ARCHITECTURAL RESPONSE

RE: Kelso Crescent Multi-Level Warehouse, Moorebank (SSD-58978472)

Response to Submissions

scale	As indicated	A1
project no	250211	
date	08.10.25	
dwn	dc	
dwg no	250211 - DA-116	
issue	A

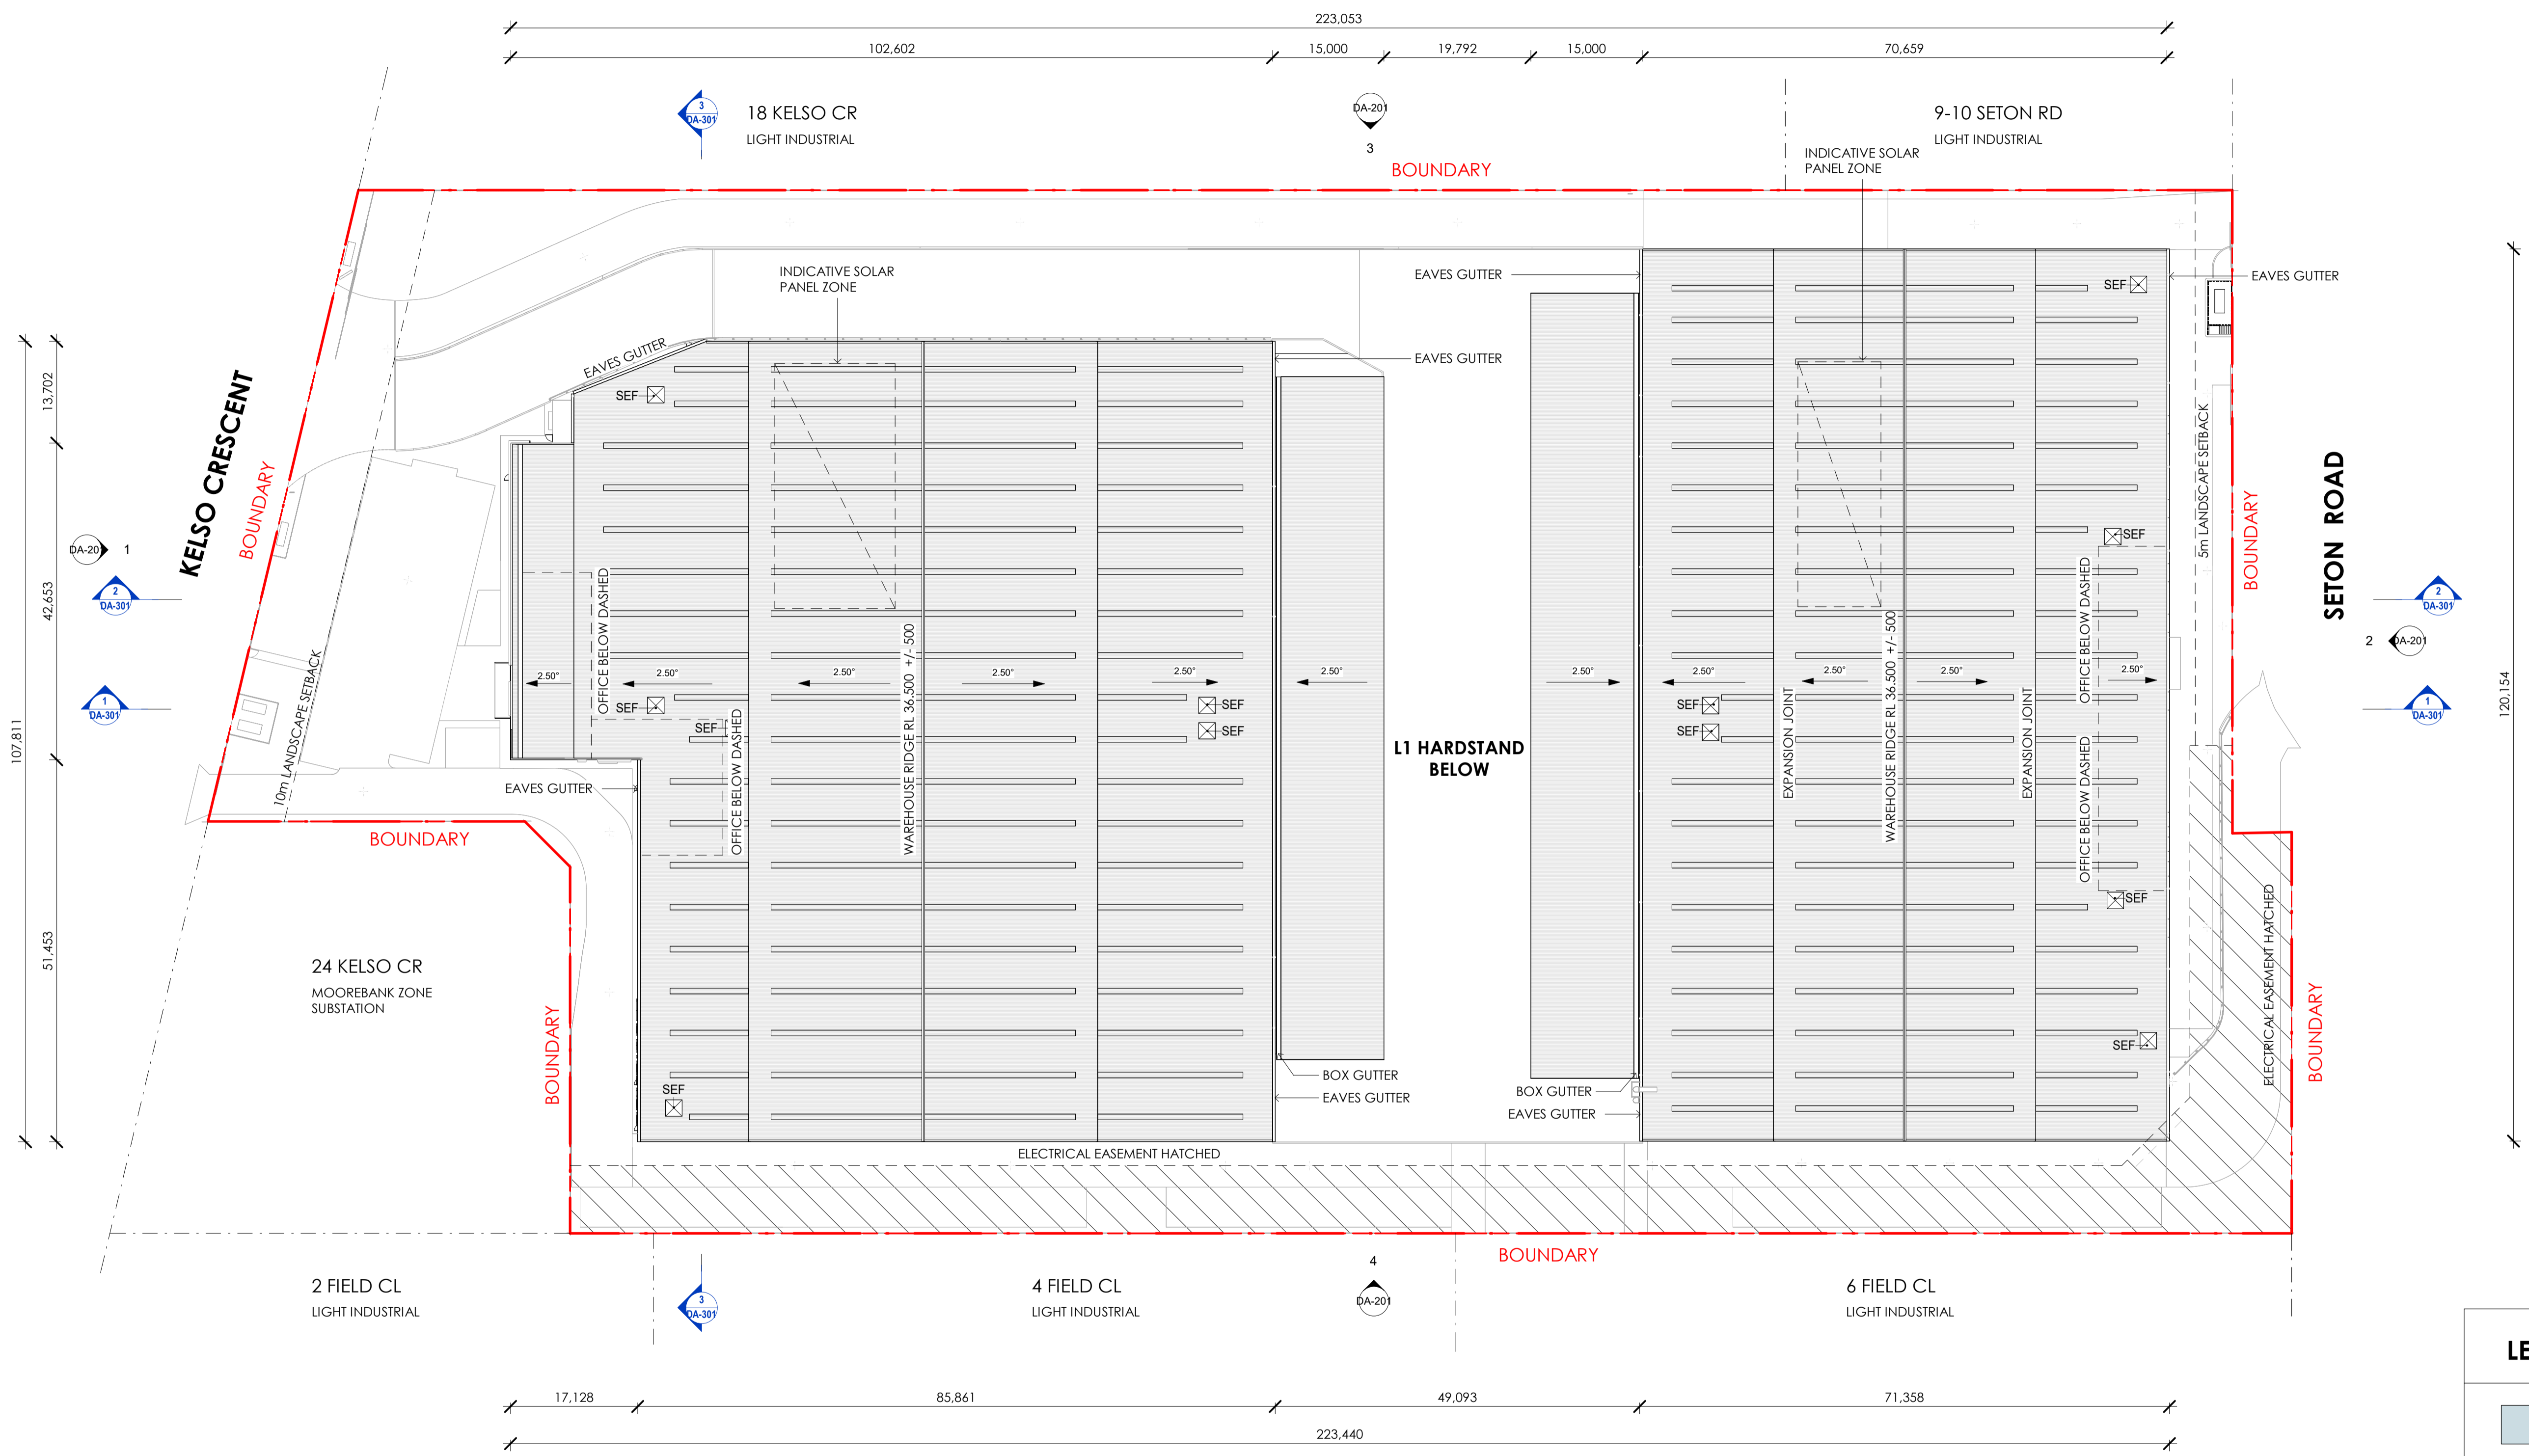
Solar Panels

- The expanse of solar panels is a very small portion of the roof.
- UD recommends the number of solar panels is significantly increased.

The Roof Plan drawing has been updated to indicate not only the proposed area of solar panels to be installed initially as part of the base building design, but also the potential for increased area of solar panel installation to suit tenant and/or future requirements.

scale	As indicated	A1
project no	250211	
date	08.10.25	
dwn	SP	
dwg no	250211 - DA-301	
issue	A

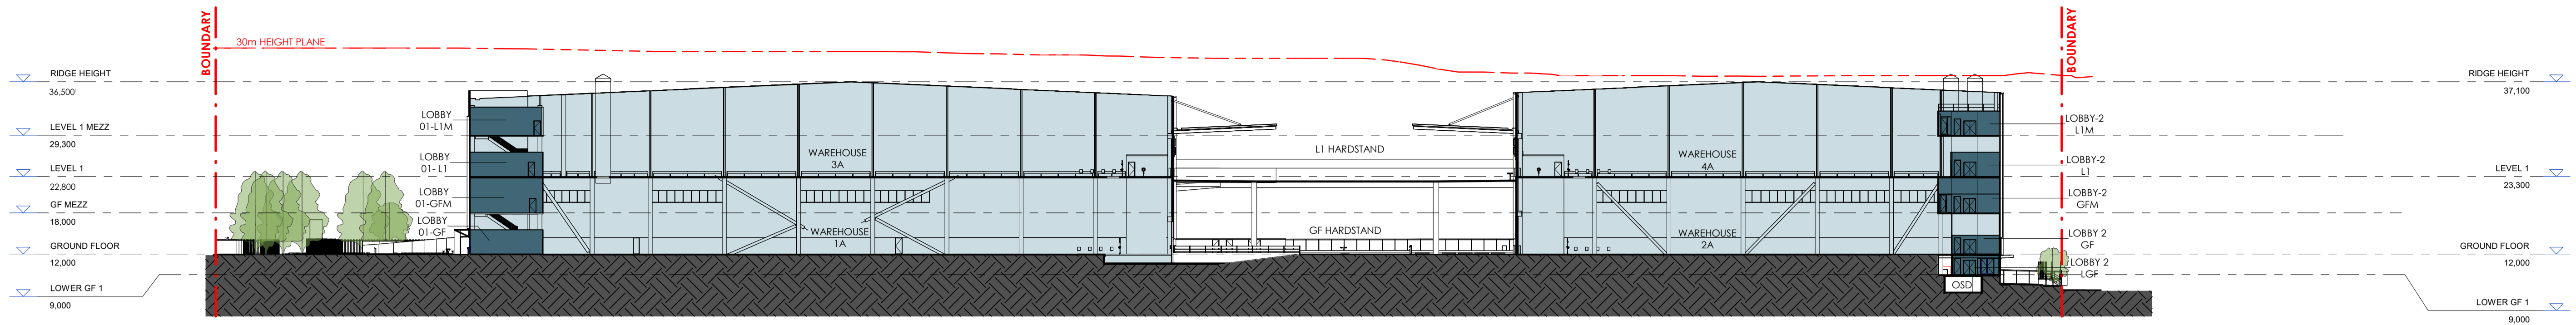
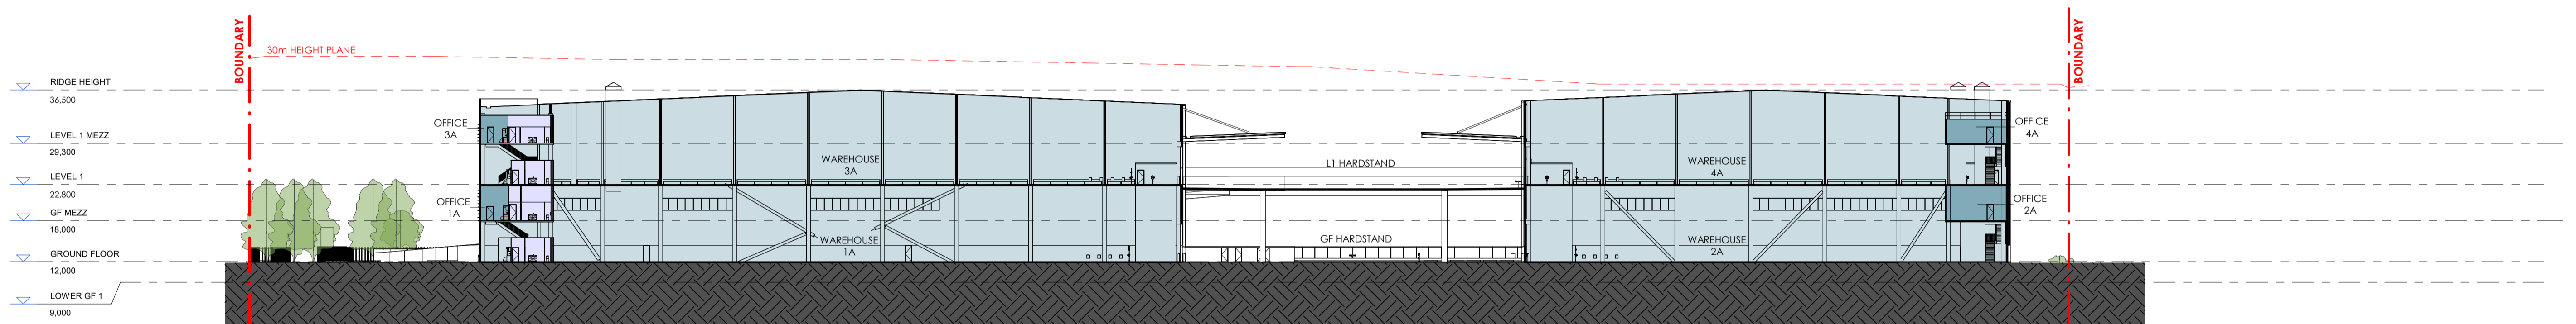
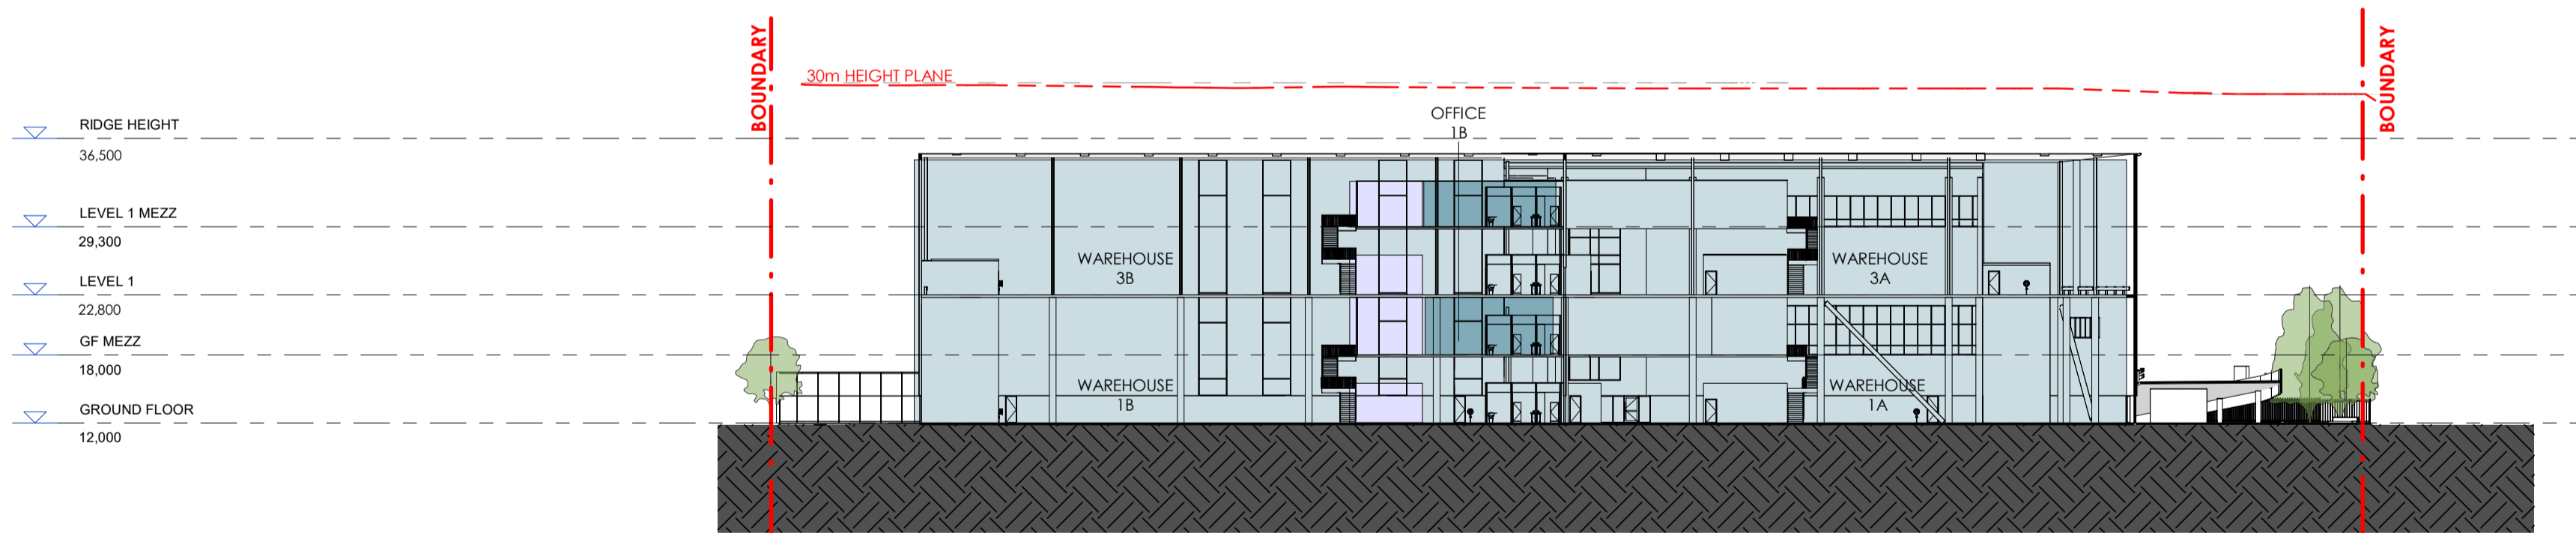
Issue:**Ground Levels — DA-301**

- *DA-301 still does not illustrate the existing natural ground line (dashed).*
- *This is especially important to understand where existing trees 15 and 17 sit in relationship to the proposed levels.*
- *This issue remains not addressed from previous referrals.*

3. The Department requests that the **existing ground levels be explicitly delineated on the plans**, as previously requested by Council. Although the Amendment Report indicates that this information has been supplied, the plans do not clearly identify the locations or contours of the existing ground levels.

Trees 15 and 17 are to be retained, and the existing ground levels within the Tree Protection Zones of these two trees is to be maintained in order to facilitate retention of the trees.
